# A38 Derby Junctions

## 8.52(a) Ashbourne Road Accesses Summary

**Ashbourne Road Accesses Summary**

Independent Safety Review Technical Note:

Drawing Title  
FIGURE 2.6  
MARKEATON JUNCTION  
GENERAL ARRANGEMENT

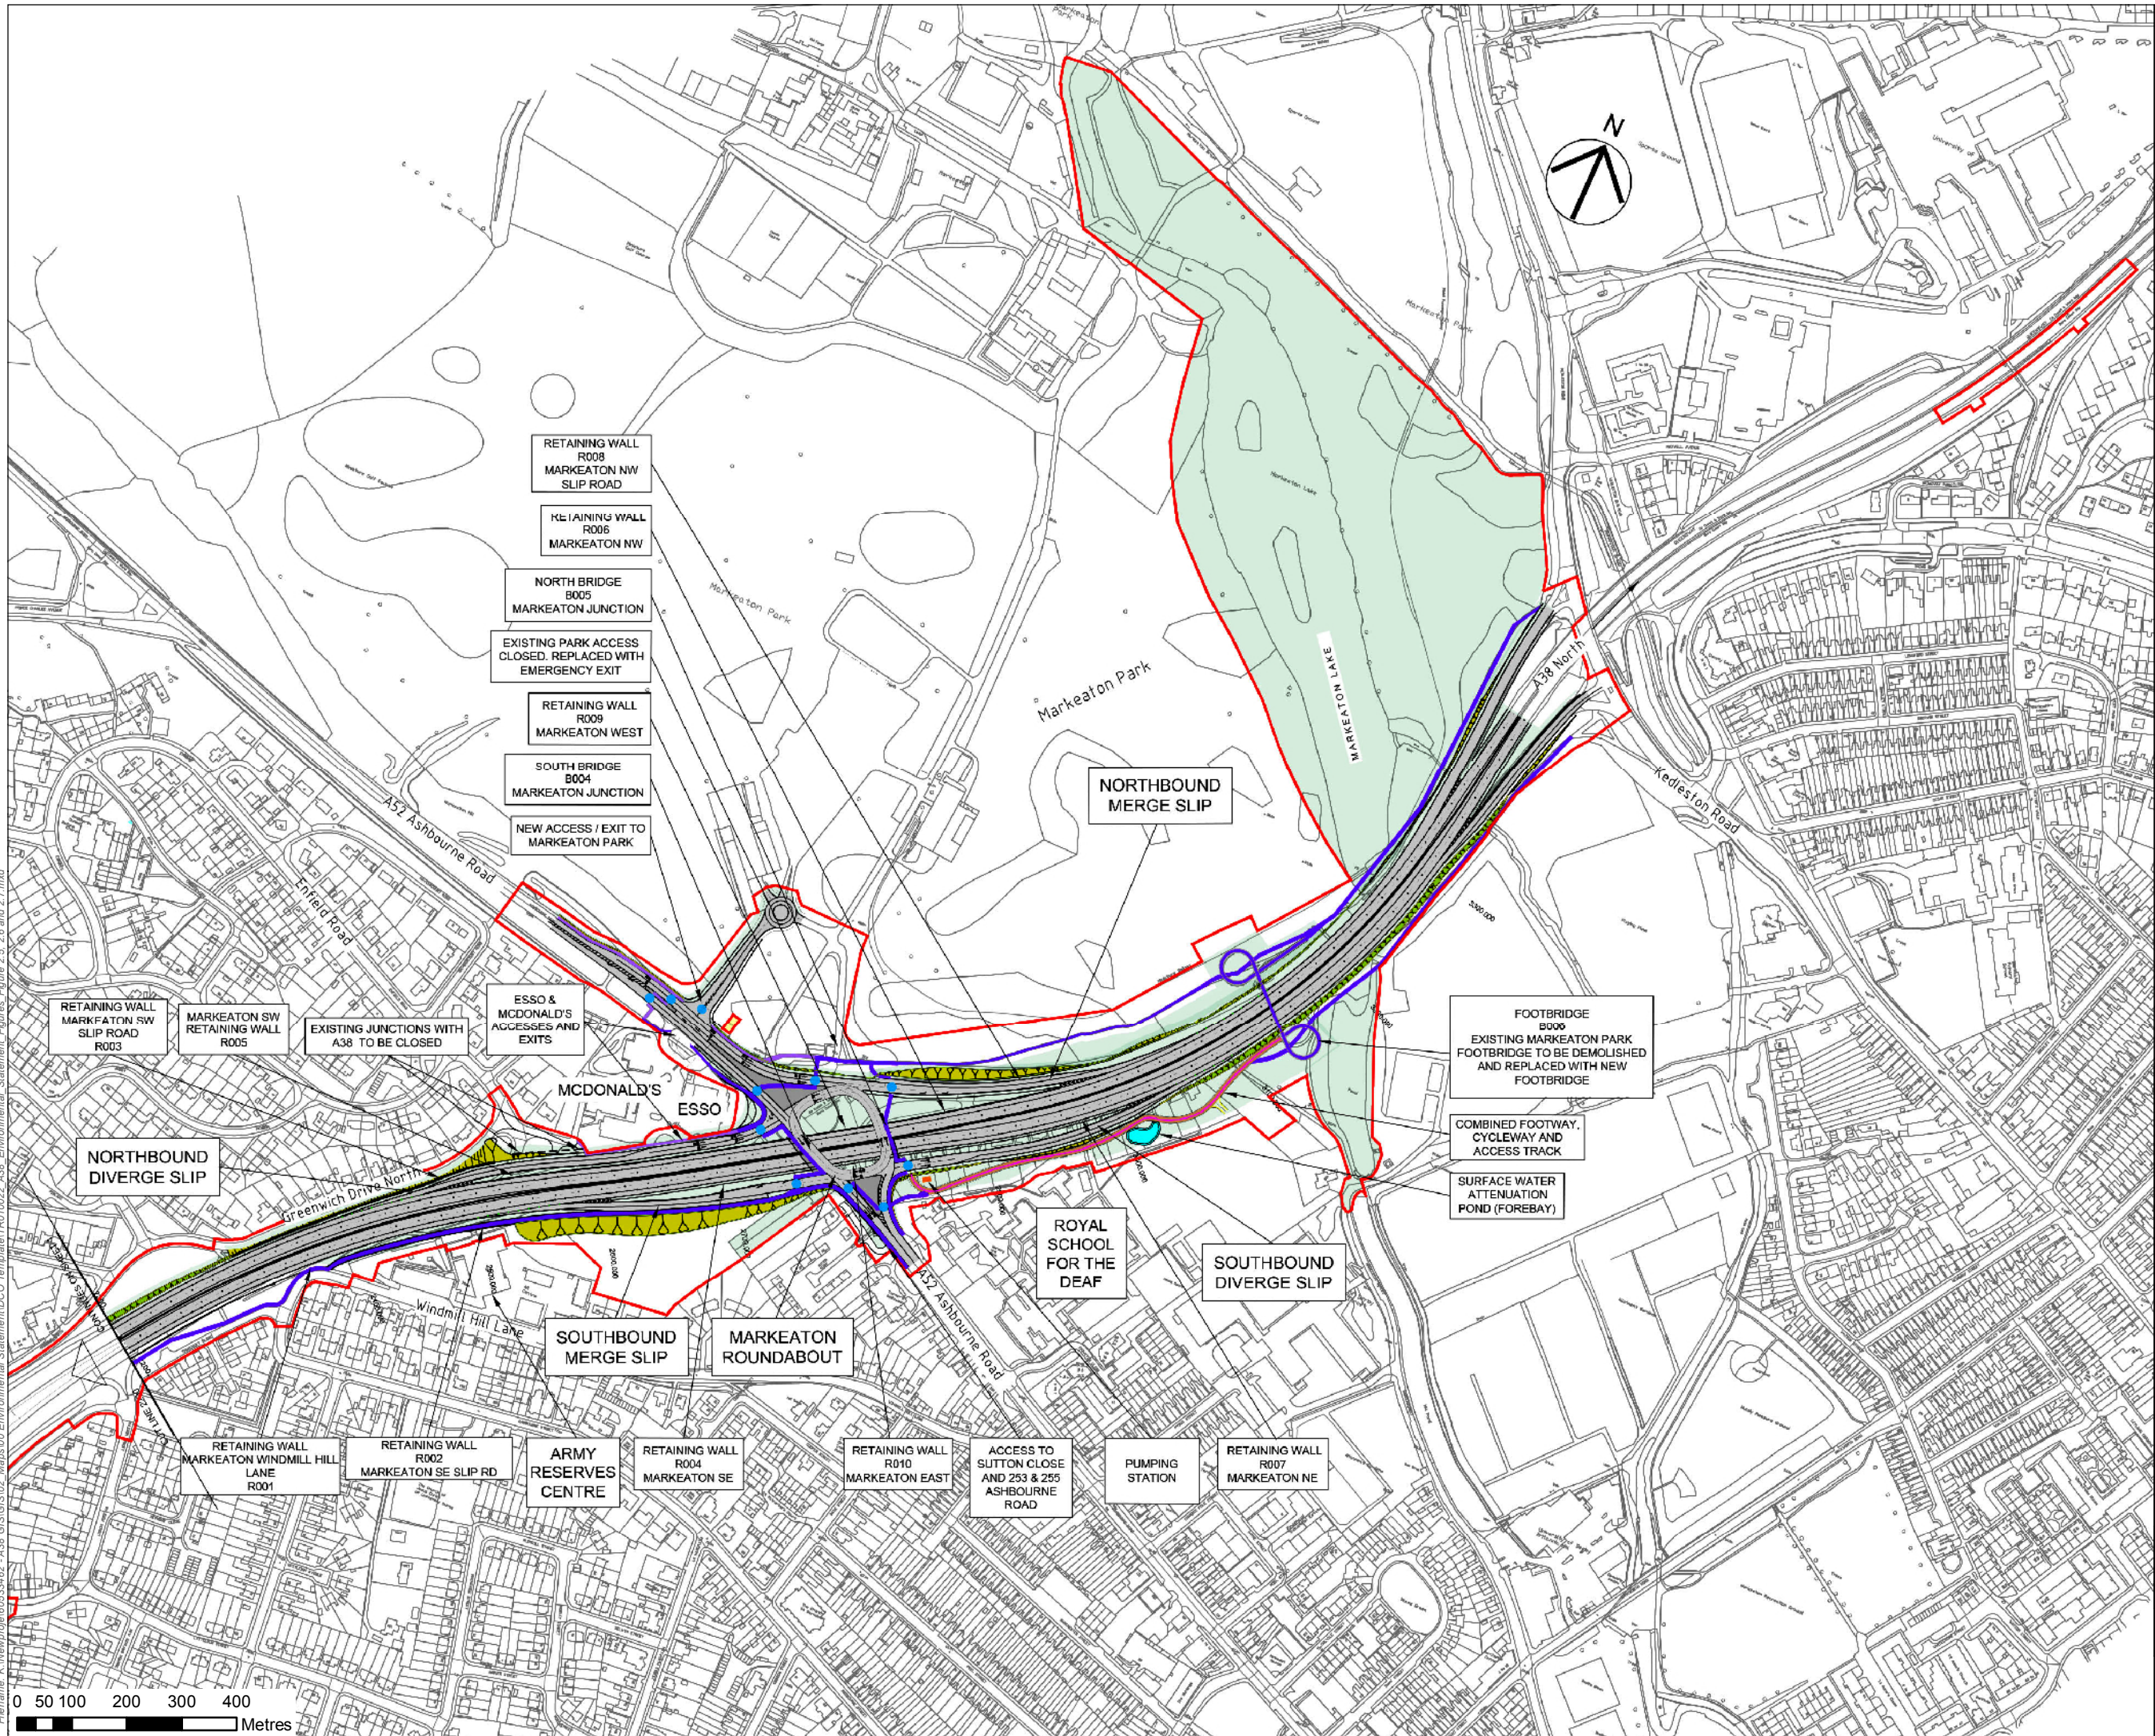
If a left in left out proposal is carried forward within the design phase, the main safety concern is the increase in turning movements along Ashbourne Road. The effect of this arrangement is likely to result in drivers attempting to U Turn at an inappropriate location along Ashbourne Road. If drivers wishing to access Sutton Close and/or properties 253 and 255 are forced to continue along the eastbound A52 Ashbourne Road there is a greater risk that unsafe, unexpected turn manoeuvres may be made.

Whilst there are several side road junctions located along Ashbourne Road which could be used as U-turn facilities the significant level of traffic located along Ashbourne Road, in both directions and during large parts of the day, will increase the likelihood of collisions occurring whilst drivers carry out these turn manoeuvres. Additionally, driver frustrations and hesitations, due to delays in selecting an appropriate gap in oncoming traffic, could also increase the likelihood of collisions occurring.

The Safety Team have also reviewed the possibility of repositioning the stop line for the westbound signalised crossing to increase the distance between a revised access to the properties to allow for left turning vehicles out of the properties to enter the A52 carriageway safely. However, relocation of the stop line further east along the A52 is likely to increase the inter-green timings which could lead to queuing traffic around the roundabout circulatory and obstruction of the A38 southbound diverge slip road, further increasing the likelihood of collisions.

An alternative to restricting access/egress to left in, left out would be to allow all movements. However, permitting vehicles to turn right into the properties may lead to several other issues, principally that the delay in clearing the exit from the Markeaton Junction could result in queuing vehicles which could potentially block the signalised crossing on the A52 eastbound carriageway.

If users of any access do not position themselves in the correct place within the A52 eastbound carriageway it could result in shunt type collisions from following traffic not expecting stationary vehicles ahead.

Careful positioning of a proposed access should be considered to provide residents with a 'safe' waiting area, clear of the eastbound lane of Ashbourne Road, to access the properties from the A52.

If a service road is provided for residents, it is imperative that all turning movements within the access/egress configuration can be safely carried out without conflict.

It is the opinion of the Road Safety Team that the design should develop a facility to accommodate an all turning movement at an access to Sutton Close and properties 253 and 255. A service road should allow for residents to access the properties located on the southern side of Ashbourne Road from the eastbound and westbound carriageway.

The service road should accommodate all potential vehicular movements with swept path analysis undertaken to confirm this.

The design options should ensure that vehicles waiting to turn right into the access are not positioned within the eastbound carriageway and KEEP CLEAR markings should be provided on the westbound carriageway across the access/egress provision.
